From: Sarah Burrow <Sarah.Burrow@arun.gov.uk>
Sent: 11 August 2021 13:44
To: Planning.Responses <Planning.Responses@arun.gov.uk>
Cc: Amber Willard <Amber.Willard@arun.gov.uk>
Subject: RE: Planning Re-Consultation on: BN/99/21/DOC

Engineers Comments Regarding Surface Water Drainage

Application No: BN/99/21/DOC

Description of Works: Approval of details reserved by condition imposed under BN/62/20/HH relating to condition 3-surface water drainage.

DRAWN BY	CHECKED BY	DESIGNED BY
PF	JL	JL
SCALE @ A1	© DATE	STATUS
1:100	July 2021	Planning
JOB NO.	DRAWING NO.	REVISION
31789	EX.01	P2

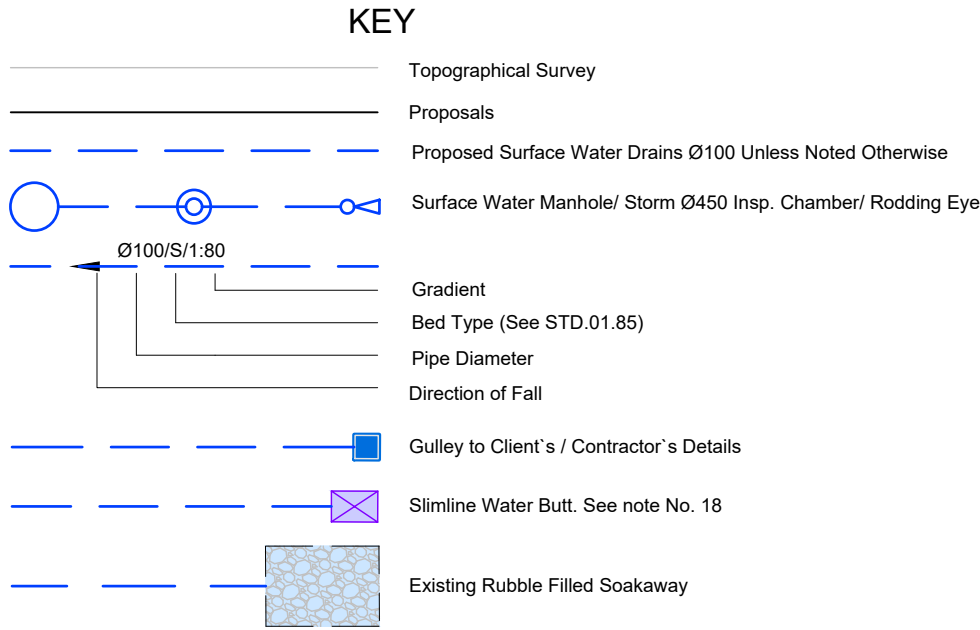
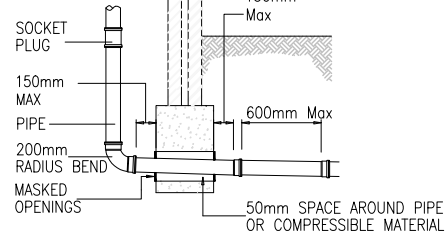
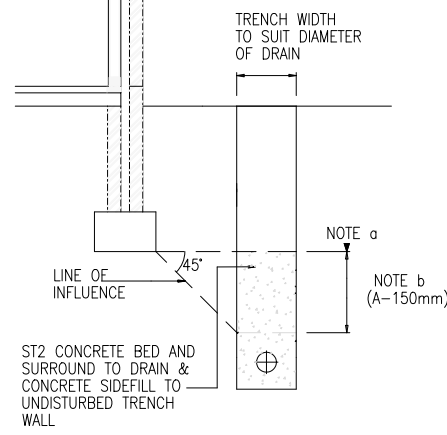
It would appear that no winter groundwater monitoring or infiltration testing has been completed on site to justify the design. This is a stipulation of the condition and I will not be able to recommend discharge of the condition without it. The groundwater monitoring for a development of this size need not be extensive, 24 hours to a week over the winter period (December- March) would be acceptable, however infiltration testing must be carried out in strict accordance with BRE Digest 365.

Once the site investigations have been completed the results must be used to inform the drainage design for the site. Therefore if infiltration is viable all surface water will be expected to drain to ground with no overflows to the watercourse. If infiltration is found to not be viable then surface water may be attenuated and discharged to the watercourse at a restricted rate.

Full details of what is required to support a Discharge of Conditions application are available through our Drainage Checklist ([download.cfm \(arun.gov.uk\)](#)). Please pay attention to Notes 10 and 11 for the level of detail required on a drainage layout and construction detail drawings. It is recommended that a copy of the completed checklist is uploaded with the application documents.

Assuming that no groundwater monitoring or infiltration testing has been completed last winter and it simply hasn't been supplied then I would recommend that this application is **refused**. A second application may be made once the necessary site investigations have been completed.
